**Addendum No. 1**

RE: Contract ID C203015  
WBS # 34839.3.10  
F. A. # HPPNHF-0918(46)-0-  
**Forsyth County (U-2579G)**  
Bridge #366 Over US-421 On SR-2667 (Hastings Hill Road)

**October 16, 2012 Letting**

REVISIONS						SHEET NO.
NO.	BY	DATE	NO.	BY	DATE	W-5
1	SCC	10-4-12	3			TOTAL SHEETS
2			4

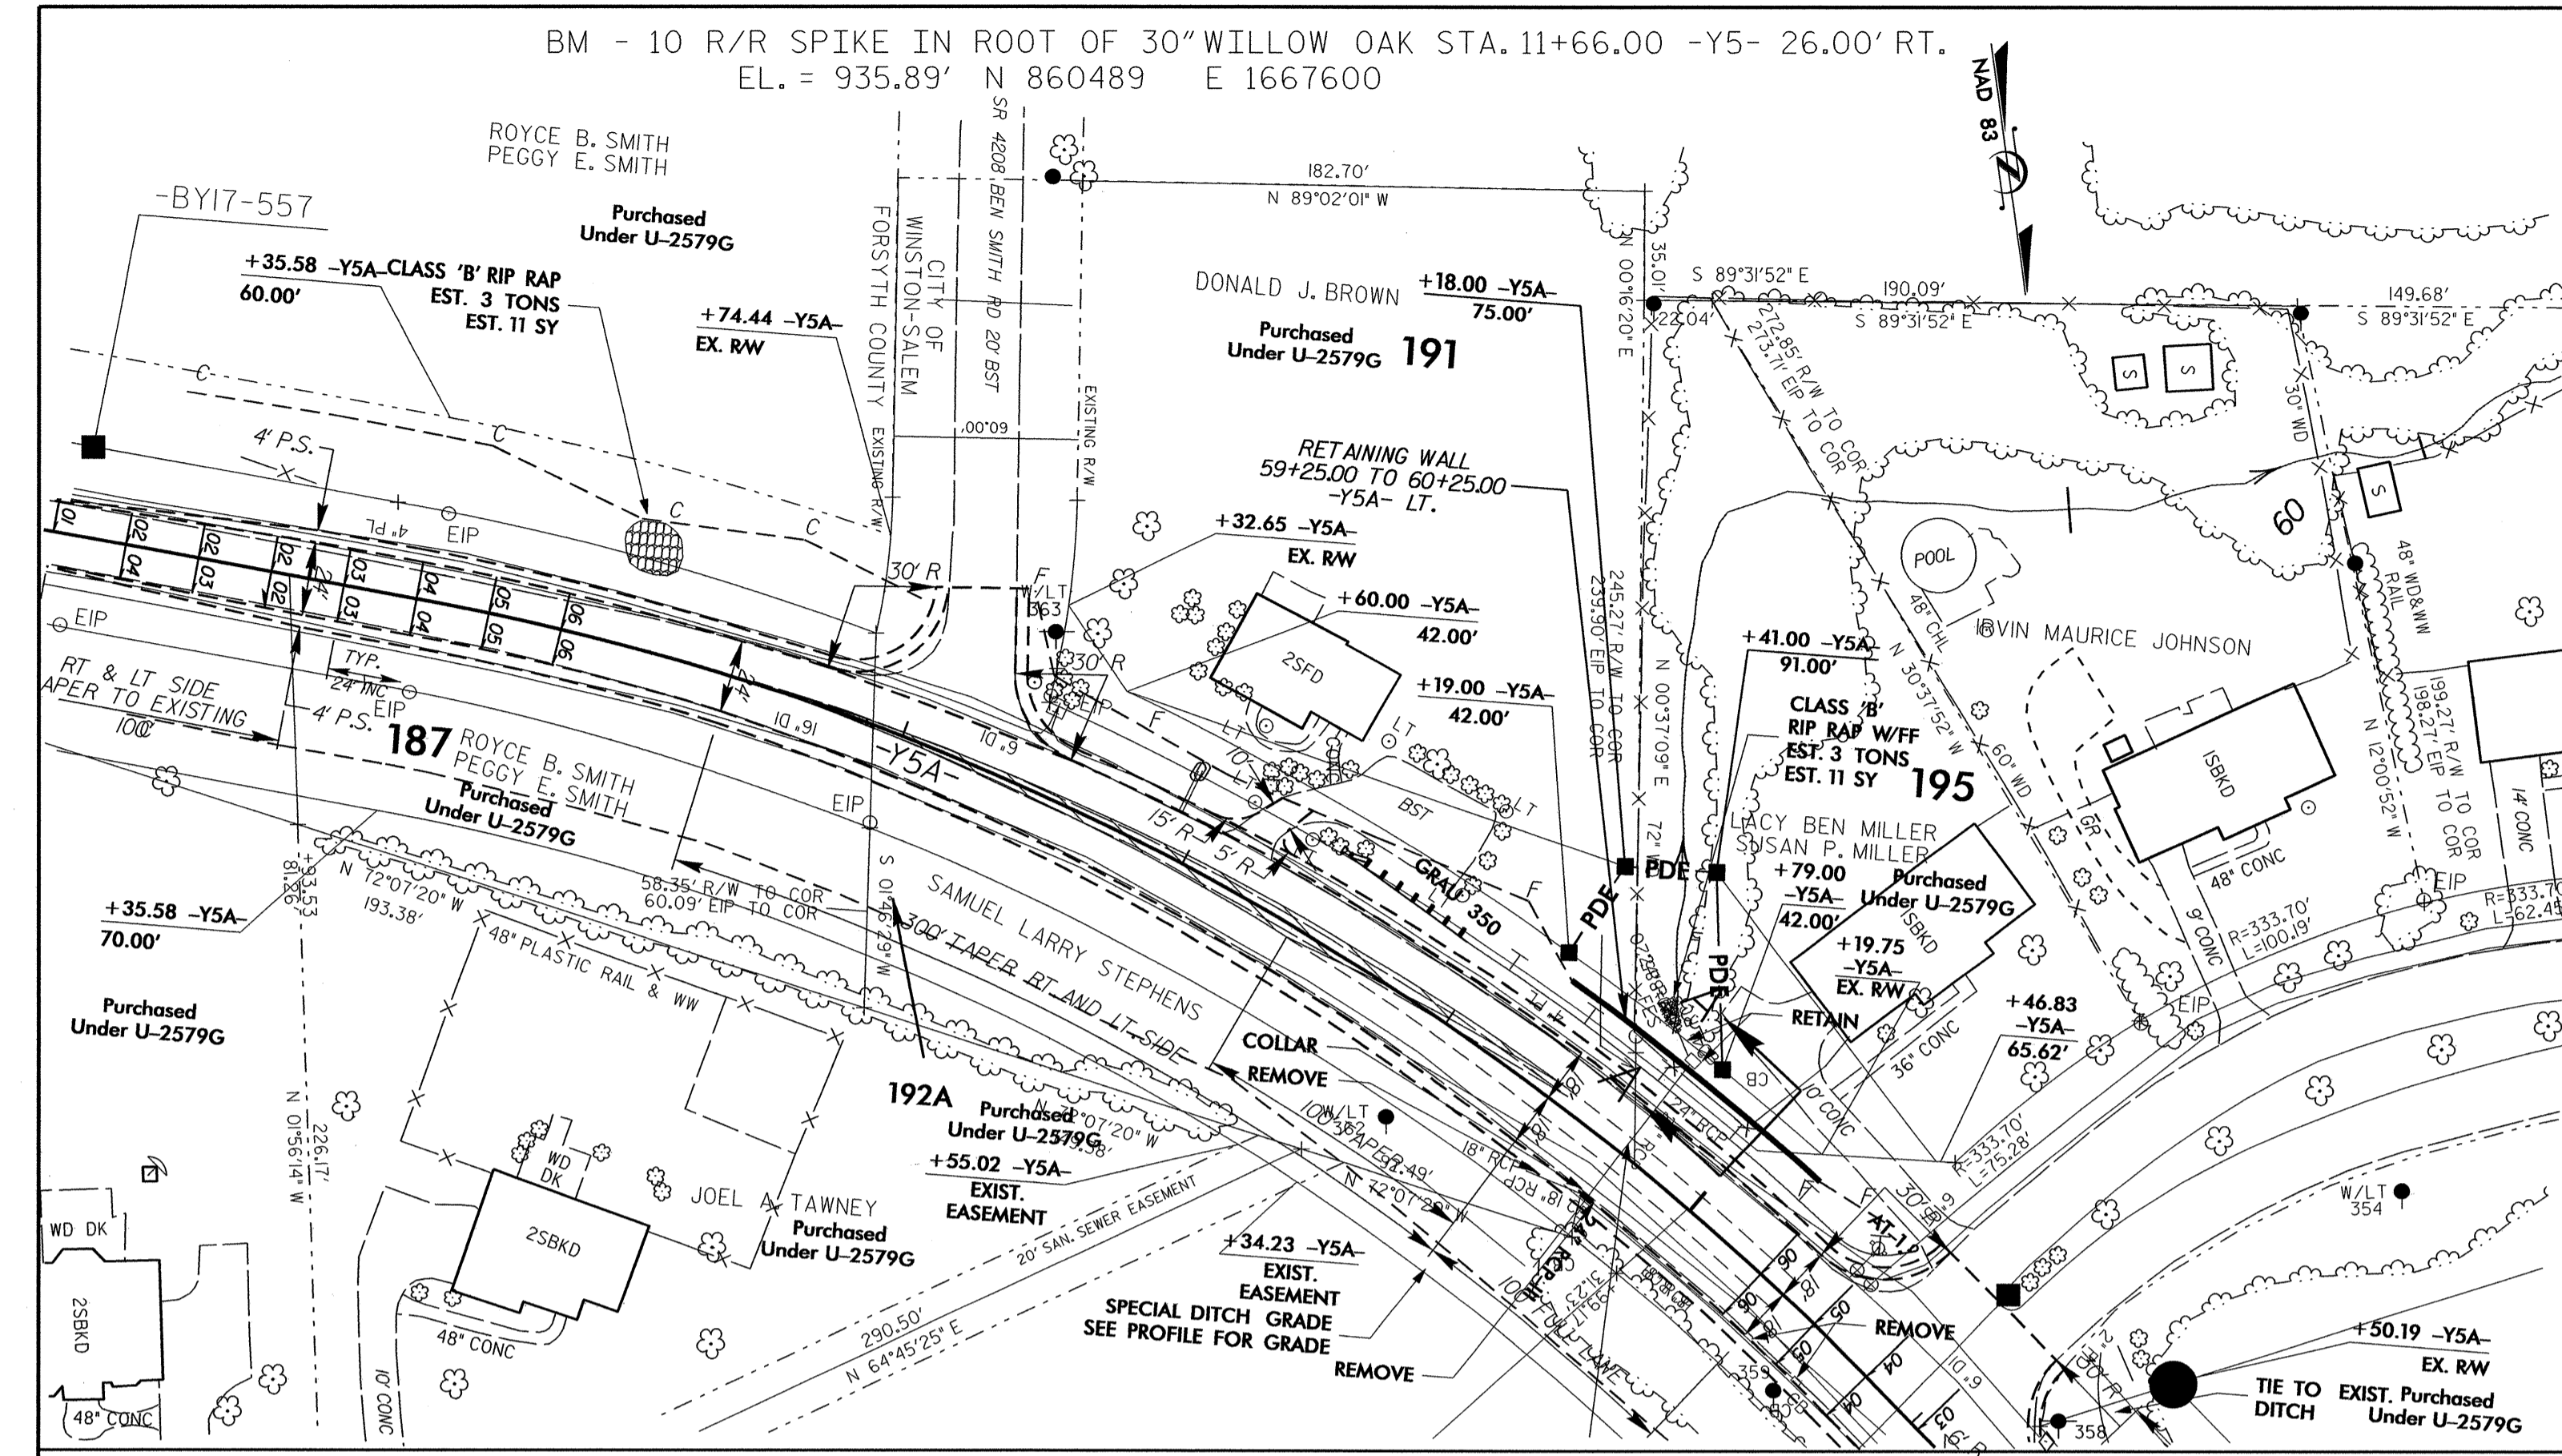
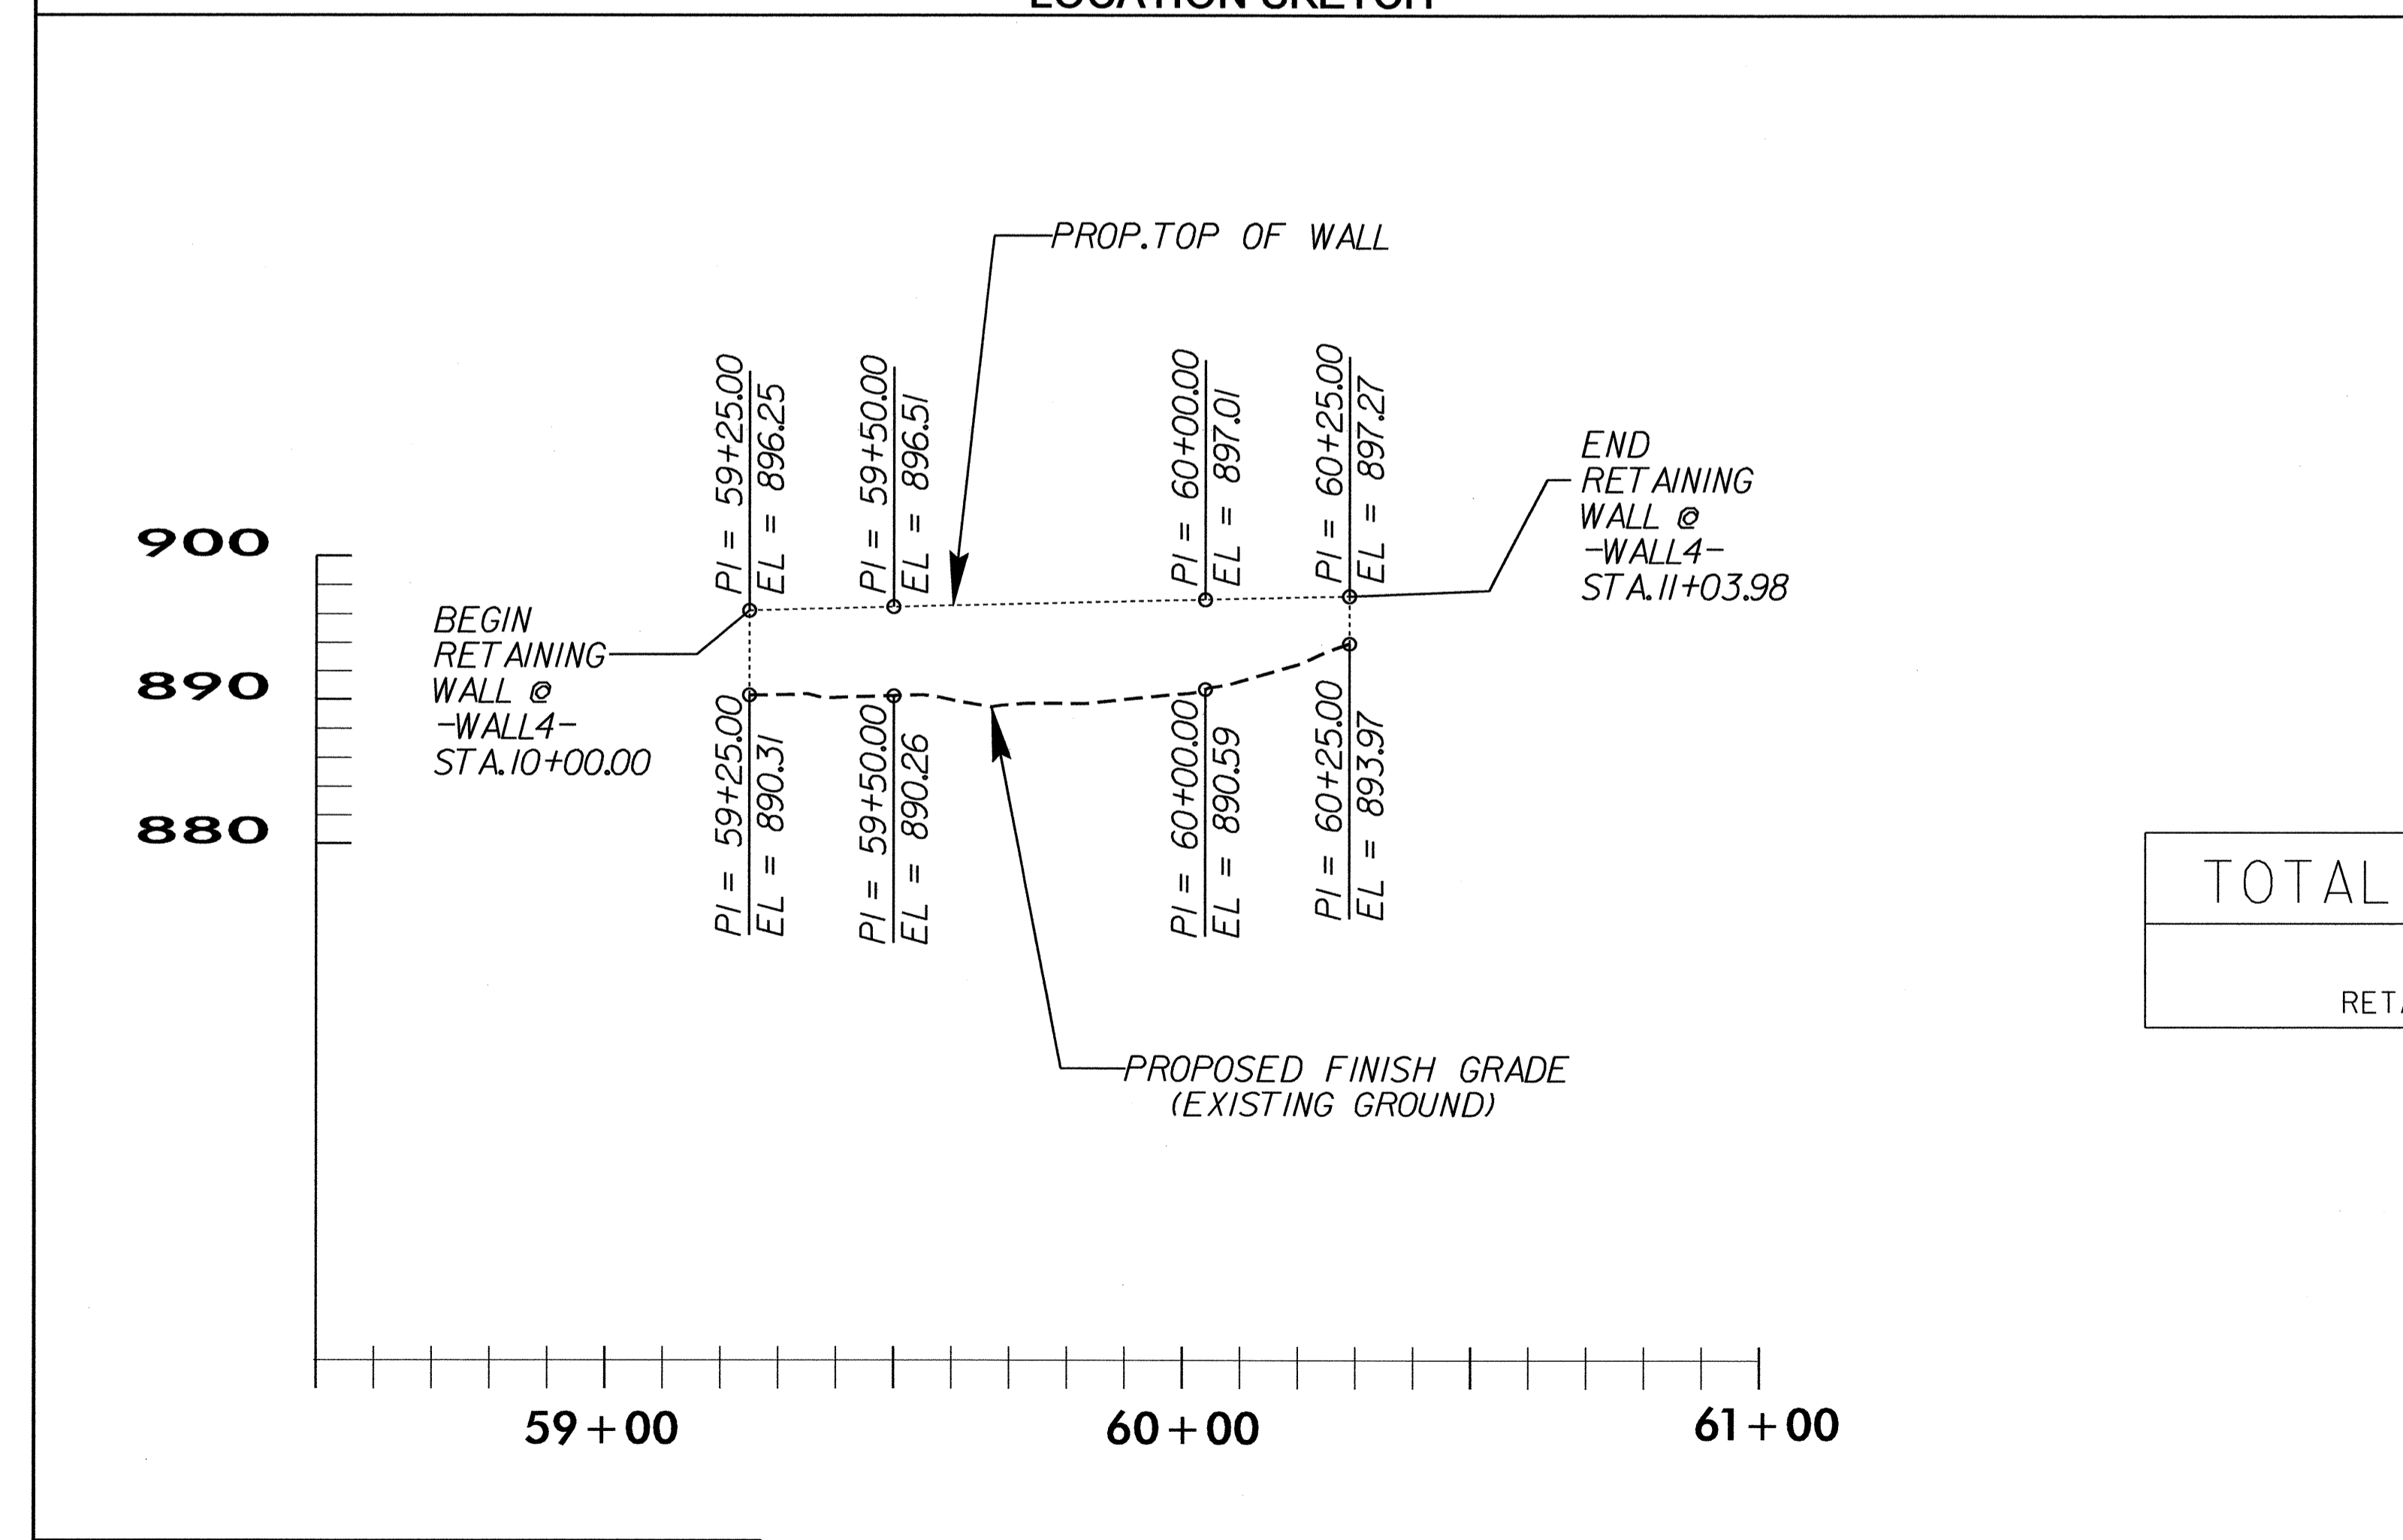
On Sheet No. W-5 the "Maximum Factored Vertical Stress On Foundation Material" value has been revised. Please void Sheet No. W-5 in your plans and staple the revised Sheet No. W-5 thereto.
